WEST SUSSEX COUNTY COUNCIL CONSULTATION

TO:	Arun District Council FAO: Anita Gardner
FROM:	Highways, WSCC
DATE:	11/07/2018
LOCATION:	Directors Cottage, Toddington Lane, Littlehampton, BN17 7PP
SUBJECT:	LU/120/18/DOC Approval of details reserved by condition imposed under LU/249/17/PL relating to conditions 3- Construction Management Plan, 5-visibility splays, 15- landscape scheme & 16-schedule of materials & finished. Amended plan received.
DATE OF SITE VISIT:	
RECOMMENDATION:	☒ Advice ☐ Objection ☐ Modification ☐ No Objection ☐ More Information ☐ Refusal
S106 CONTRIBUTION TOTAL:	£n/a.

Drawing: DETAILS [re:conditions 5&16]

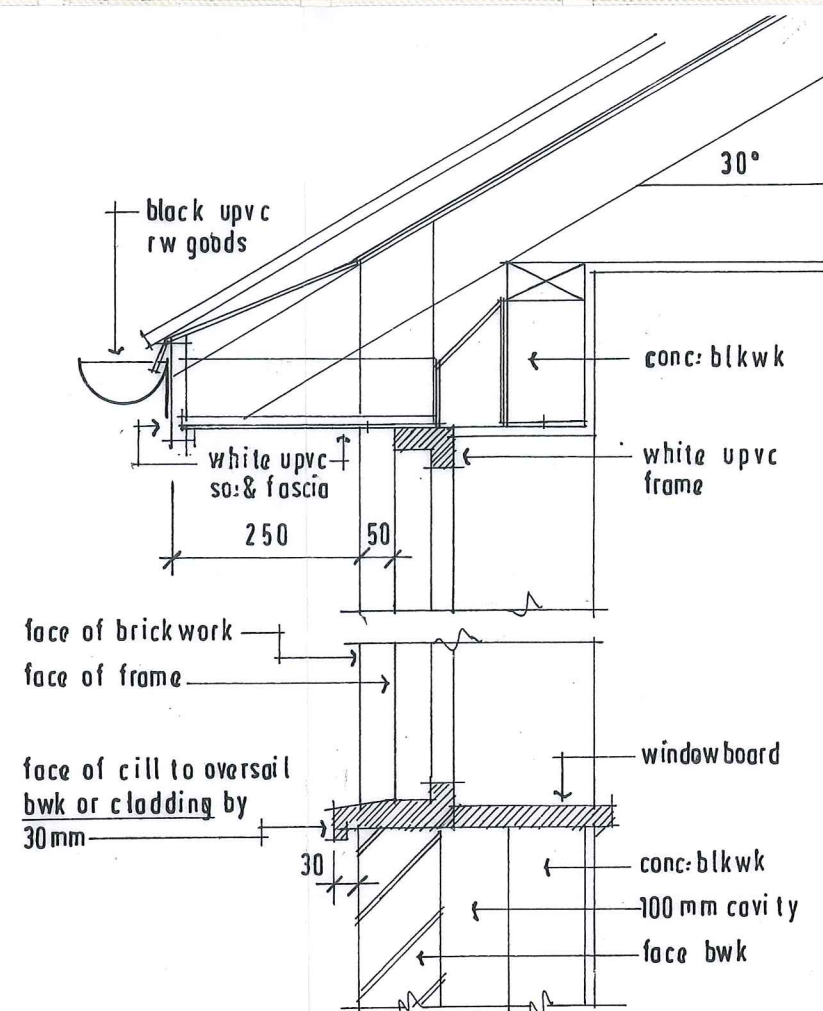
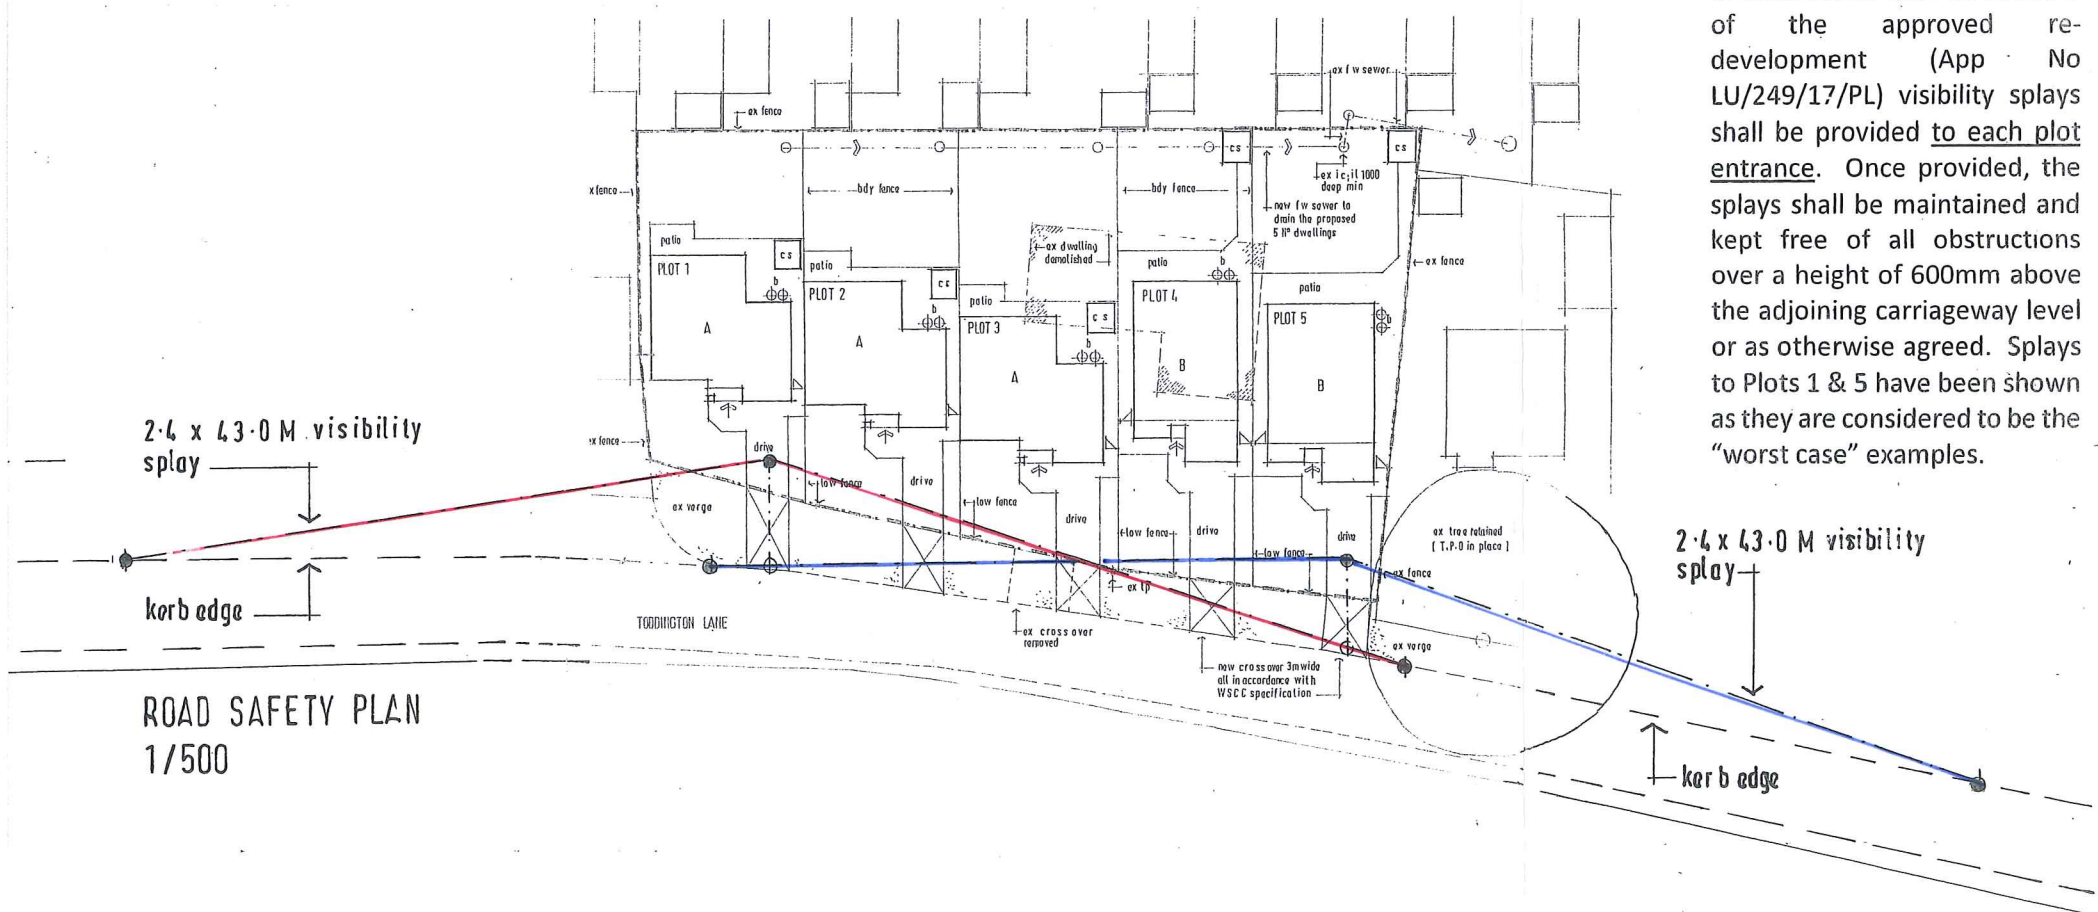
The documentation provided demonstrates that appropriate visibility can be achieved from the end-most of the 4 proposed properties along Toddington Lane.

It is considered that the accesses as demonstrated are suitable for their proposed use, visibility must be retained as per these plans.

The LHA are satisfied that this condition may be discharged.

APPENDIX 1 - SITE PLANS - NOT TO SCALE

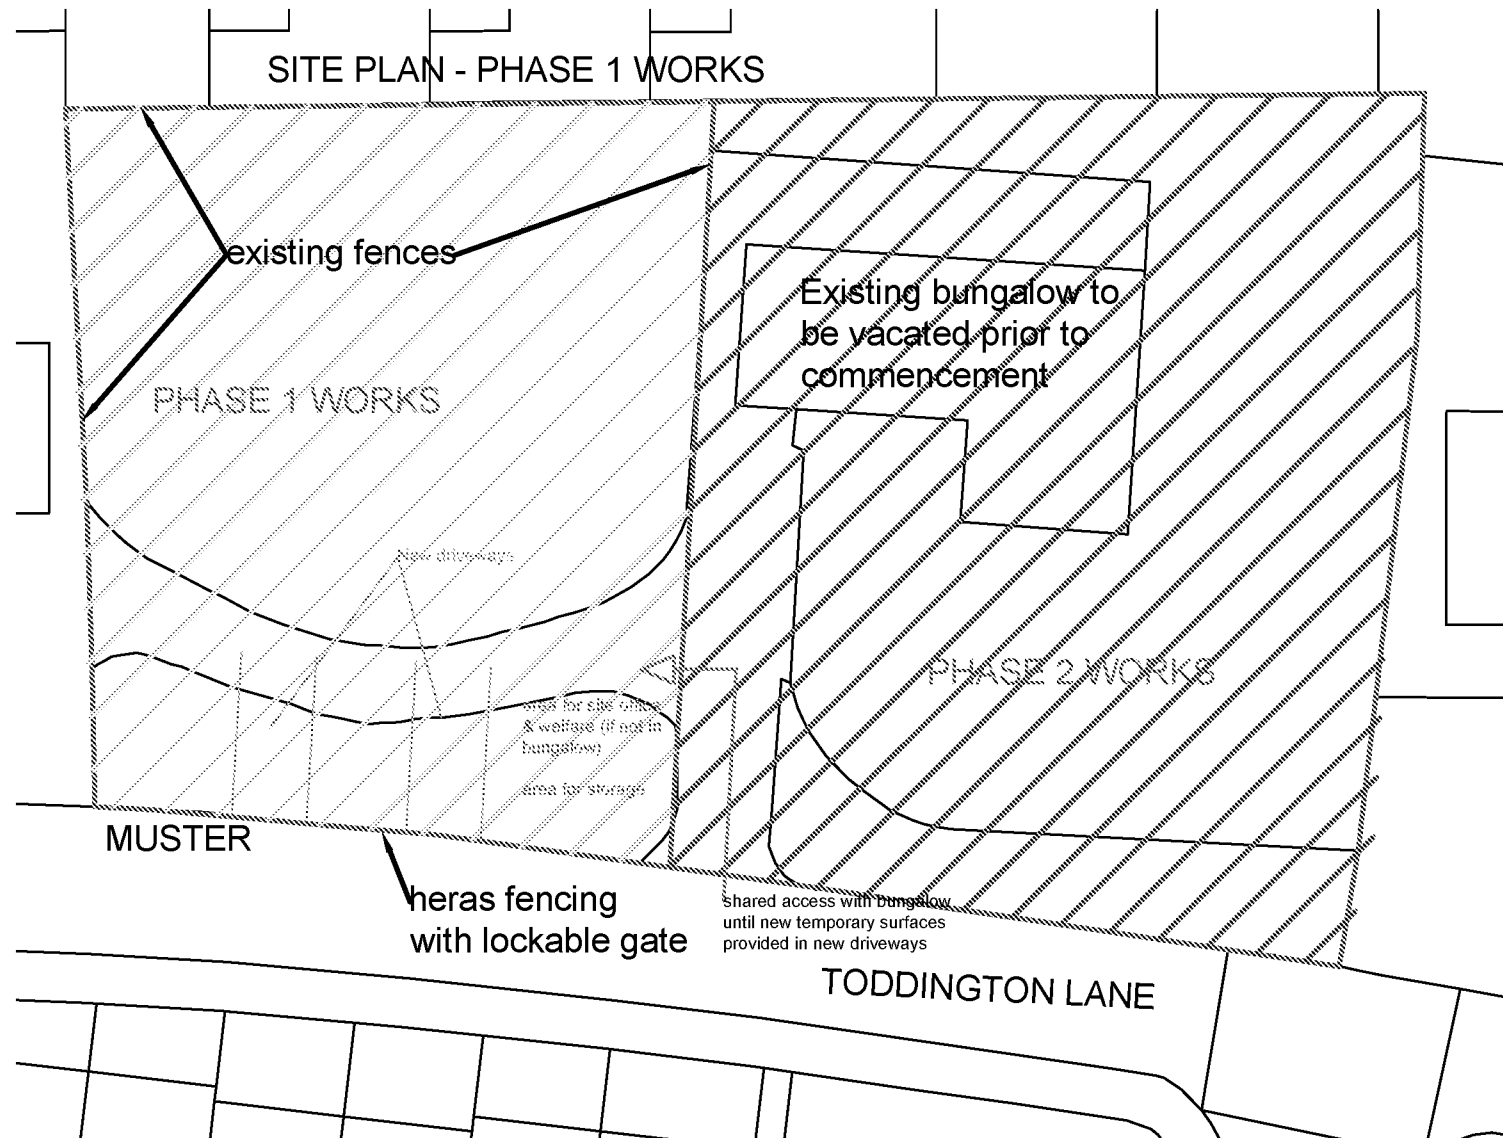
The details included within the construction management plan adequately outline the proposed access and site layout during construction and means to ensure minimum risk of conflict with users of Toddington Lane. Deliveries must be taken outside of the peak network times to avoid undue congestion around the local network. Wheel washing is available should it be required and deliveries and construction traffic are to be dealt with within the site, a banksman will be available to assist vehicles into and out of the site. The applicant is required to enter into discussion with the Area Officer regarding the placement of signage in the highway.

On this basis the LHA are satisfied that this condition can be discharged.
